**KIRKLEES METROPOLITAN COUNCIL
INVESTMENT & REGENERATION SERVICE**

**DELEGATED DECISION TO DETERMINE APPLICATIONS FOR LISTED
BUILDING CONSENT**

Reference No: 2019/65/91861/E
Site Address: 381, Bradford Road, Batley, WF17 5XT
Description: Listed Building Consent for replacement windows
Recommending Officer: Sue Oakley

600 x 1300 Ref B

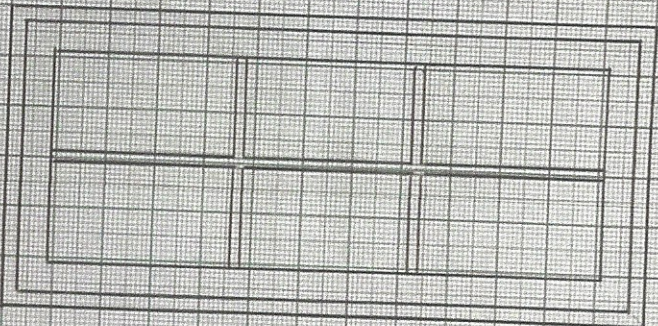
B – This window is a multi-paned side hung casement.

3. Notwithstanding the details provided, windows A, B, C, D, E, H, I, J and K shall match the existing joinery details in terms of material, profiles, detailing, beading and colour, with an increase in the internal section sufficient to accommodate slim double glazing. Windows F and G shall match the joinery details of window H in terms of material, profiles, detailing, beading and colour. All slim double glazed units shall have 4mm glass with a 6mm gap and black spacer bars.

1300 x 2200 Ref F&G

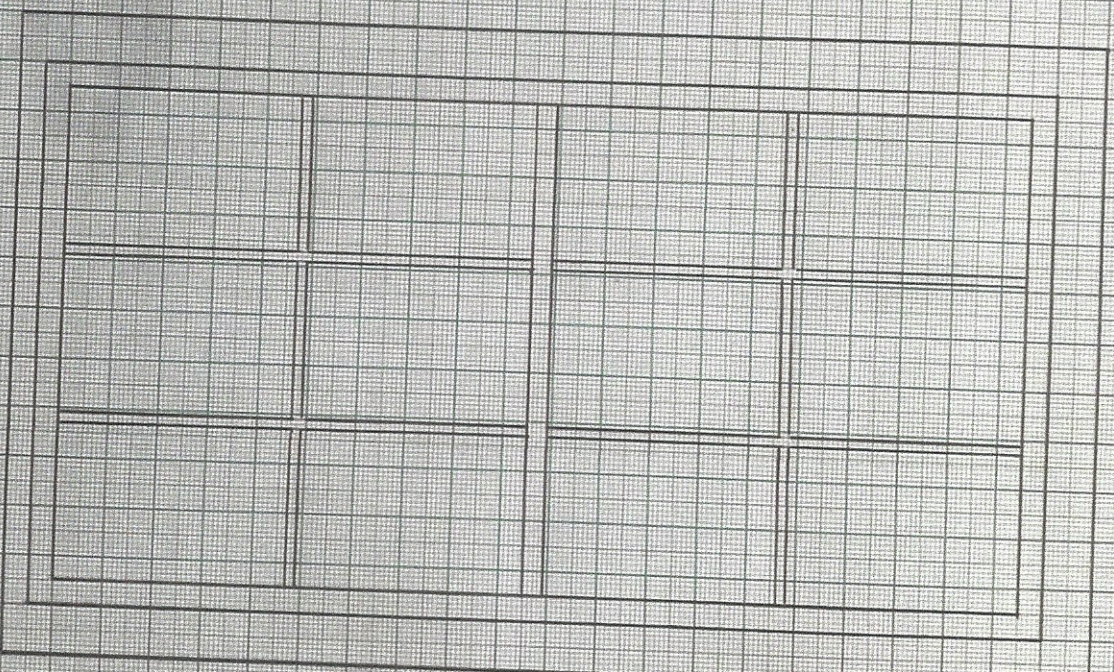
F and G are single paned sliding sash windows in timber surrounds. The applicant proposes the replacement of these with multi-paned timber sash windows without horns to reflect the style of the other large sashes on this

elevation. This is considered to be acceptable as it reflects the characteristics of the other sash windows on this elevation.

1100 x 1900
 98mm BOXING
 50mm SASH FRAME
 18mm GLAZING BARS
 REF I B J

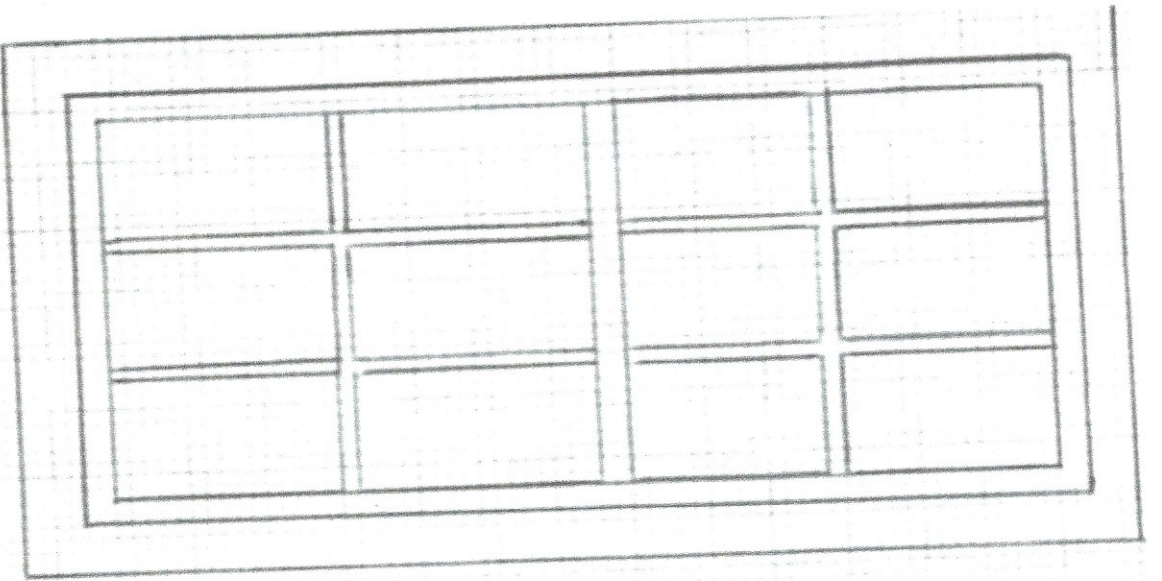
I and J – These multi-paned timber sliding sashes without horns are the most prominent windows of the application, located towards the front of the side elevation.

600 x 1000
 30mm EXT FRAME
 60mm INTERNAL PANEL
 18mm GLAZING BAR
 REF C,D,E

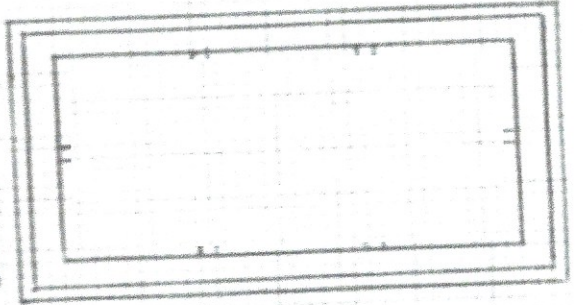
C, D, E – Each of these windows are single pane side hung casements.
